Lake Lothing
**THIRD
CROSSING**

Document SCC/LLTC/EX/97: Responses to the Examining Authority's Second Written Questions

PINS Reference Number: TR010023

Date: 12 April 2019

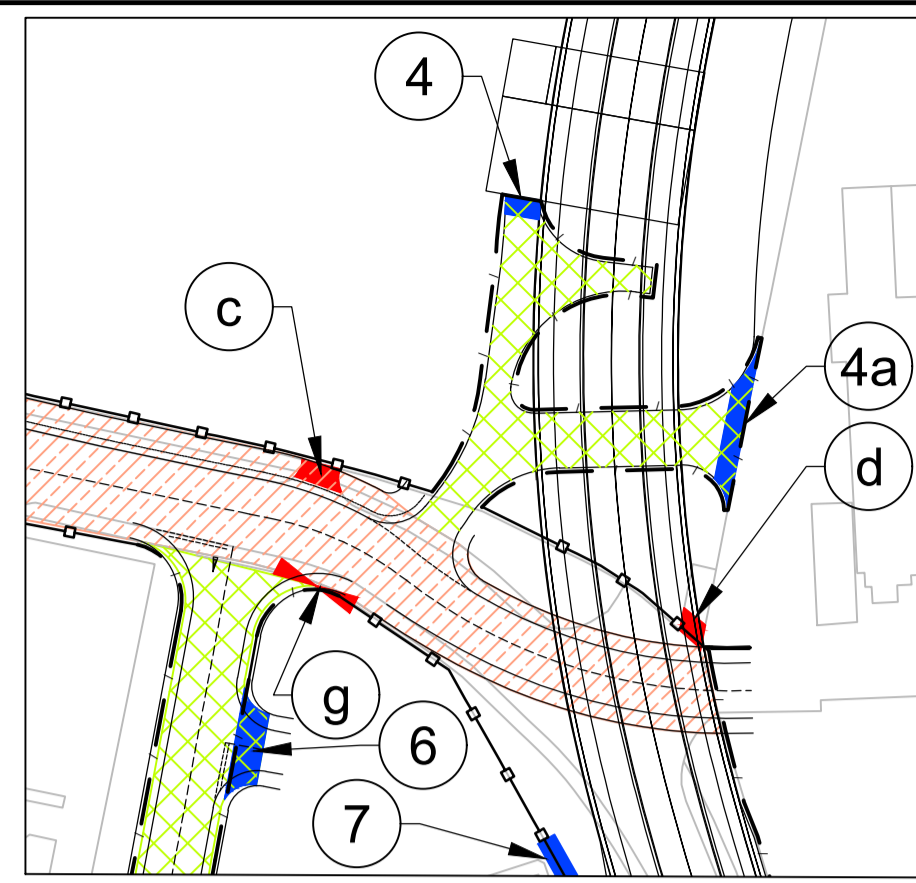
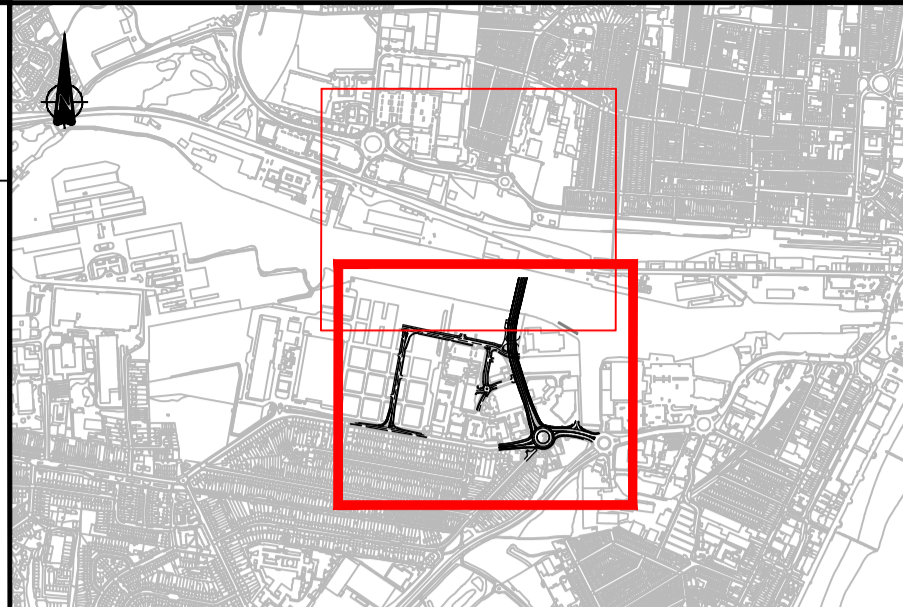
1.5	The Applicant	The new Private Means of Accesses 10 and 11 shown on the Rights of Way and Access Plans	The new Private Means of Access (PMA) References 10 and 11, shown on Sheet 2 of the Rights of Way and

ExQ	Question to	Question	Response
		Sheet 2 of 2 [APP-027] do not appear to connect to a public highway?	Access Plans [APP-027] do not connect to the public highway because they are not intended to link private land to the public highway. Rather, their function is to ensure connectivity between land which is held in different ownerships (i.e. Nexen and Lings) for the purposes of facilitating the future exercise of the new rights which are proposed to be created and acquired pursuant to the DCO for the benefit of the Applicant (to maintain the southern approach to the new bridge) and for relevant statutory undertakers (to access, install and maintain apparatus) along the length of the 'strip' of land comprised in the blue plots numbered 3-29, 3-32, 3-50, 5-10 and 5-31 on sheets 3 and 5 of the Land Plans [APP-021].
